Application for Planning Permission for Works or Extension to a Dwelling

Development: Single storey rear extension following demolition of existing extension.
Location: 25 Kingsmead Felpham PO22 7BD

Plan Inconsistencies

Existing Ground Floor Plan Scale 1:50

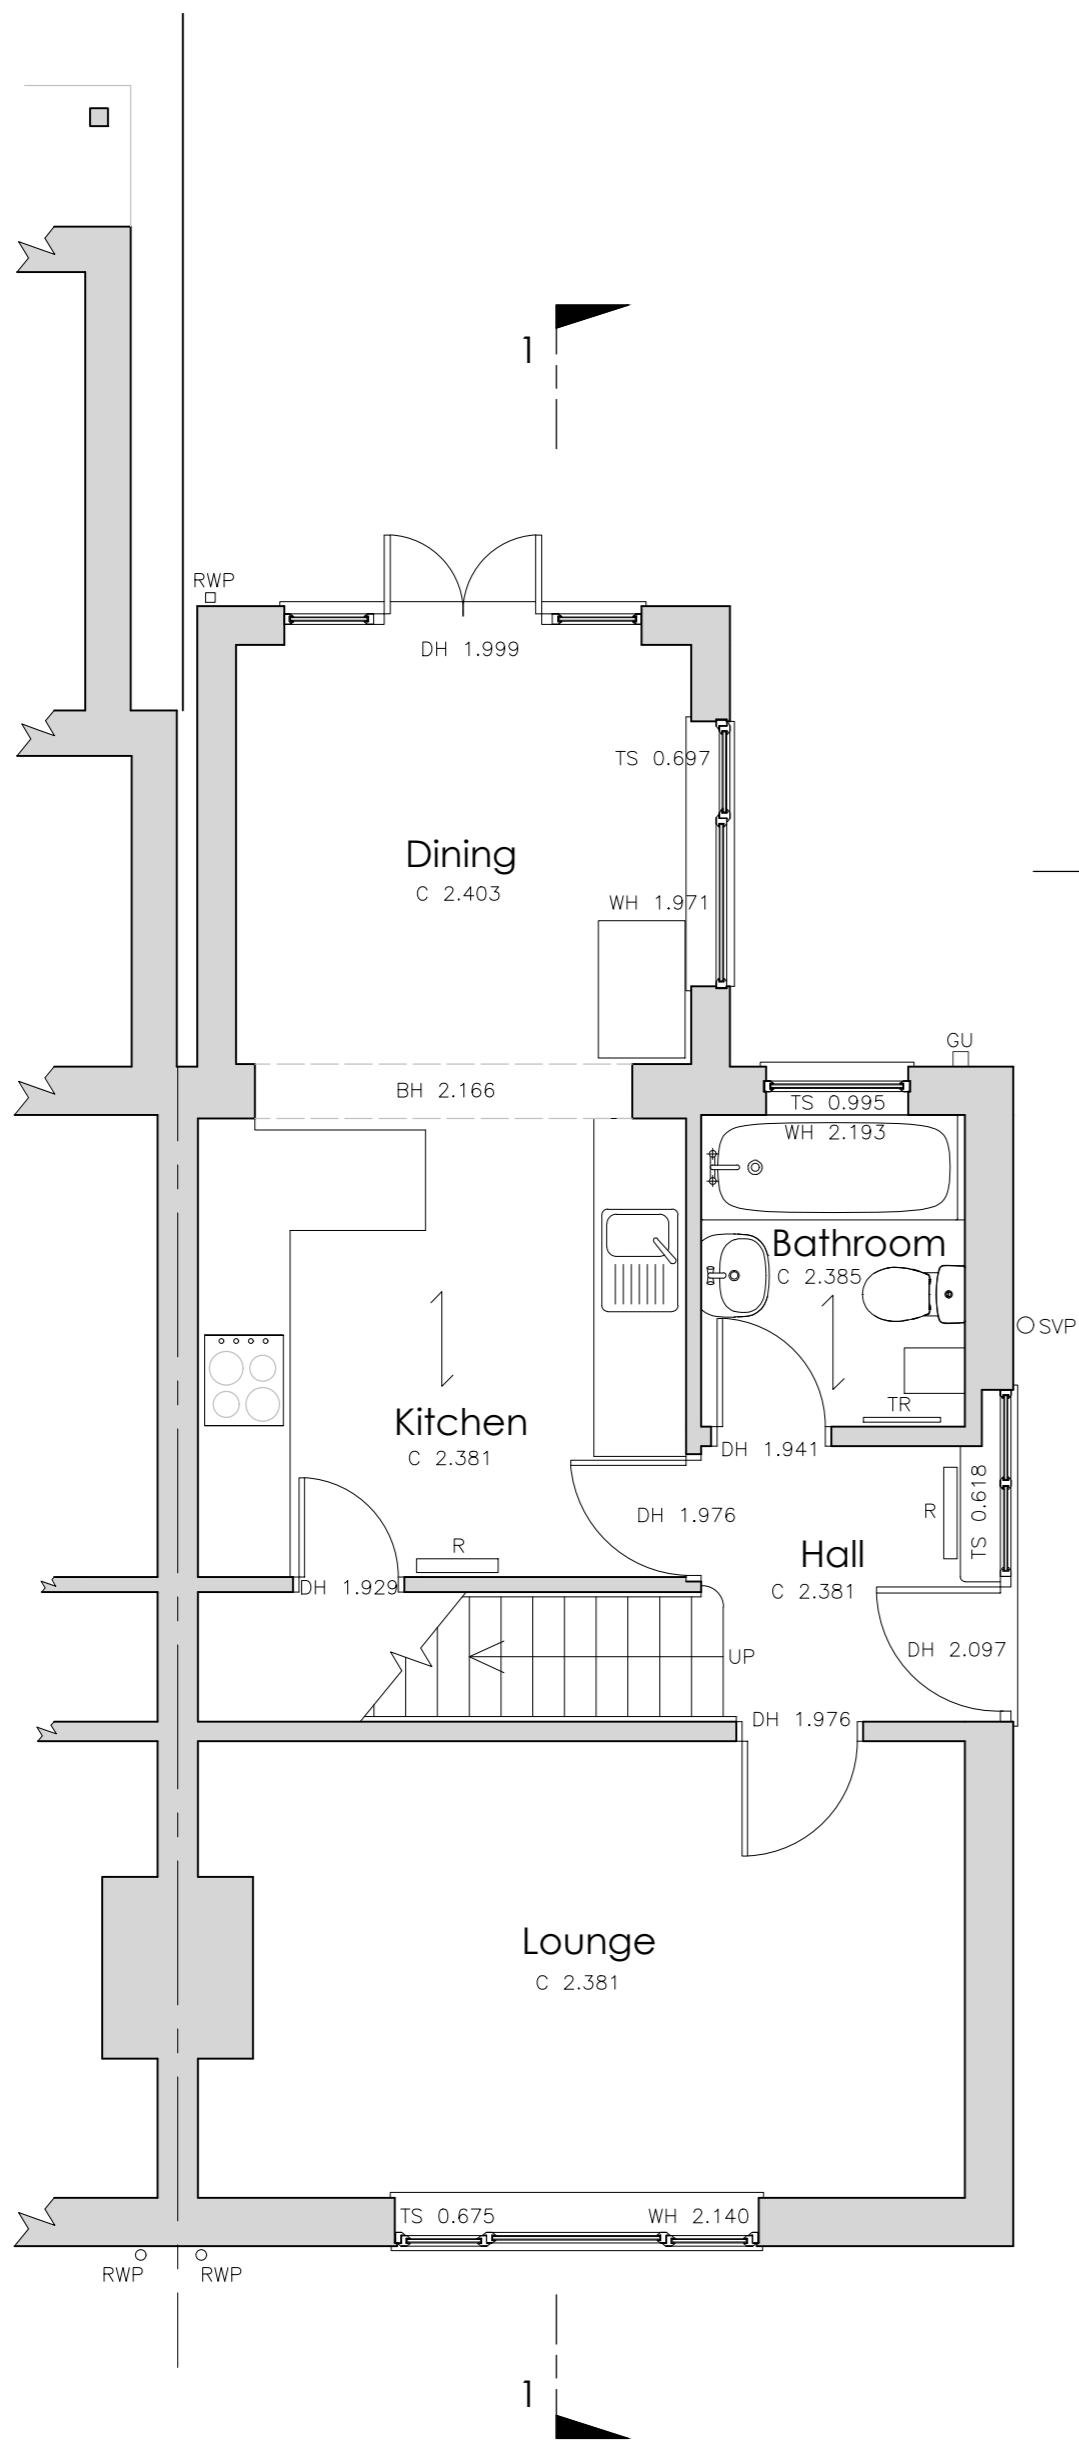
- The bathroom window on the existing ground floor plan is missing from existing side elevation.
- The extension measures inconsistently between the proposed ground floor plan and side elevation.
